ADC PARKS & GREENSPACE ARBORICULTURE CONSULTATION

PLANNING APPLICATION: BR/114/12/T

ADDRESS: Rear garden of Flat 1 32 Normanton Avenue Bognor Regis PO21 2TU

BRIEF DESCRIPTION: Reduce crown by 2m and thin by 5% to 1 No Oak tree

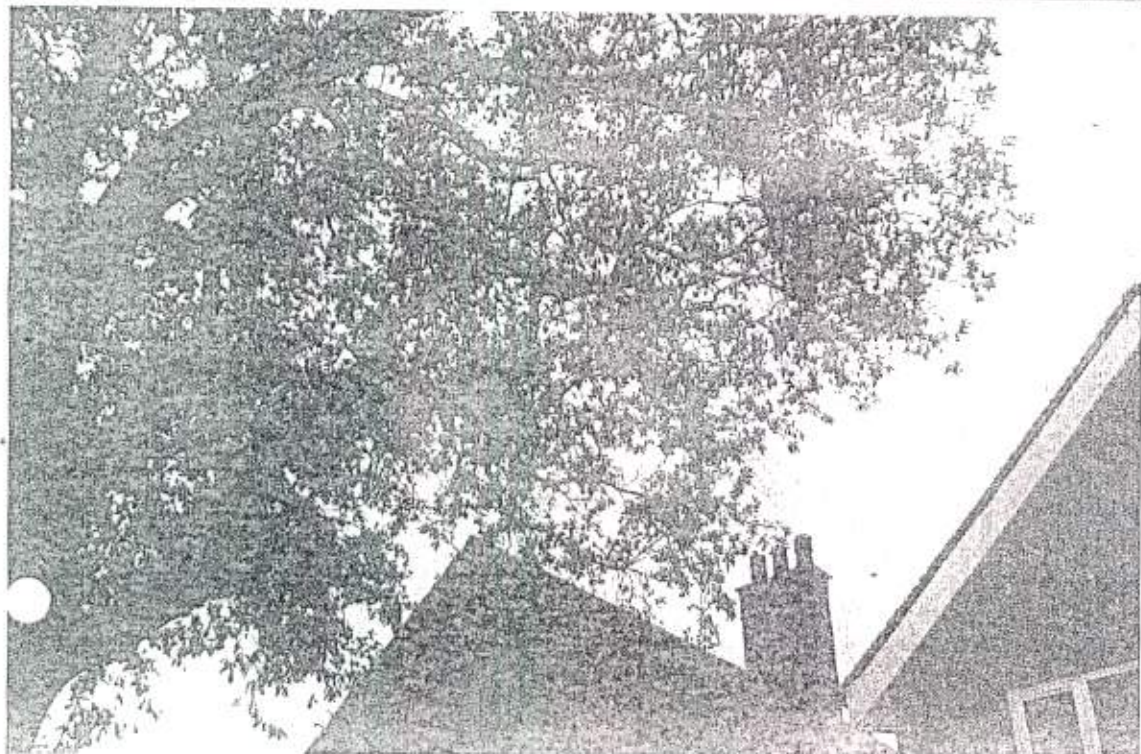
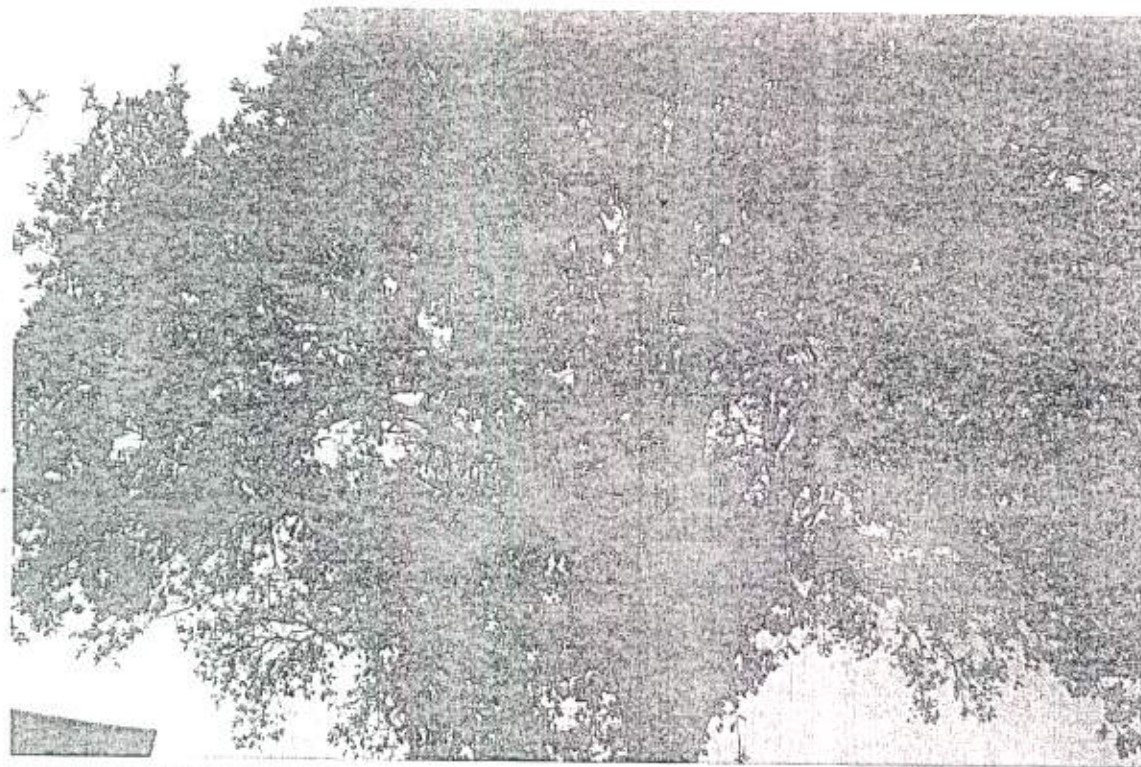
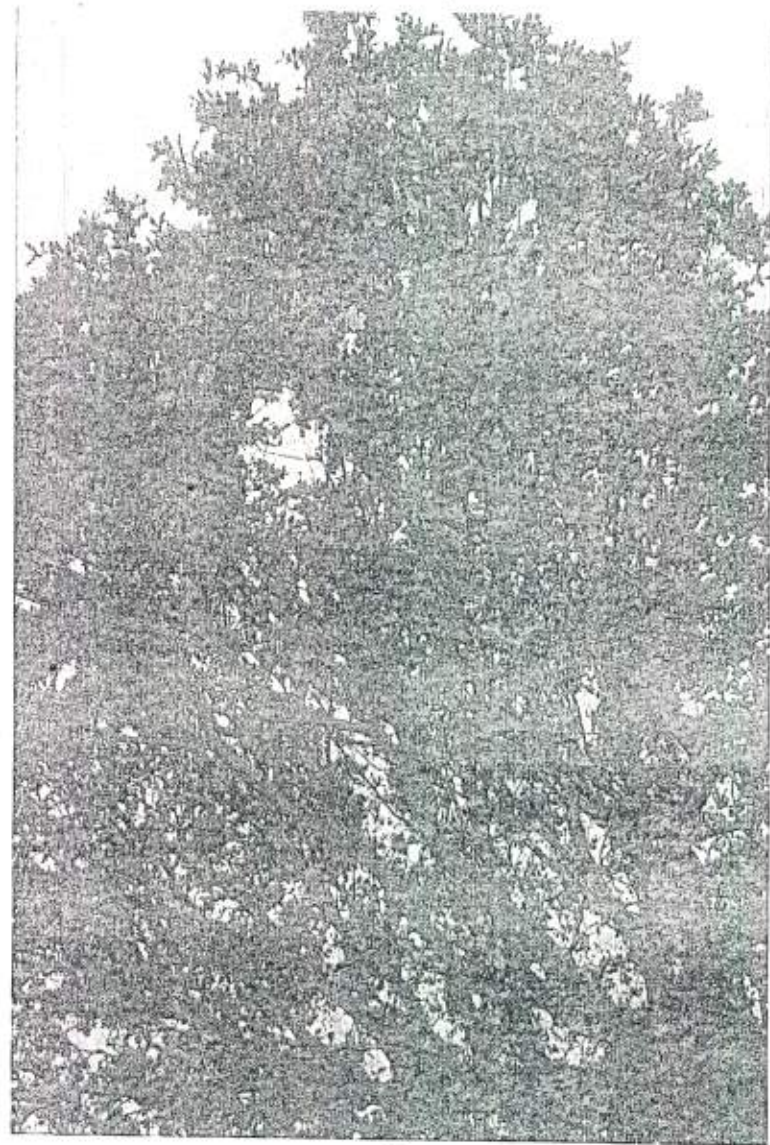
I have visited the site and identified the English Oak tree. The tree is mature, healthy, of good height and located to the rear of the property. The tree crown is near to the house and dominates the garden. A crown reduction would reduce its impact upon the householder and allow some reprieve from shade and bird problems.

The English Oak tree could accommodate a crown reduction without affecting its overall natural beauty and visual amenity. A crown clean would be beneficial to remove weaker growths and dead wood from its crown. There is a developing inner green core and this should be retained to fill out an otherwise open crown form. Suggested Conditions must include working to BS3998 (2010) and the following two, below.

- The Crown Reduction should not exceed the removal of branch lengths greater than 2m.
- All pruning cuts must leave healthy leaf bearing side branches which are 1/3rd or greater in diameter of the removed branch.
- Pruning cuts must be flat and smooth, kept as small as possible and cut at an optimum angle leaving the branch collar intact.
- Pruning wounds of all removed live branches must not exceed 100mm in diameter.

- The Crown Clean consist in the main of deadwood and stub removal.
- All cuts should be made to the branch collar.
- The weaker of two or more crossing branches should be reduced or removed.
- The remaining branch/branches should be shortened and reduced retaining half of its foliage bearing part.
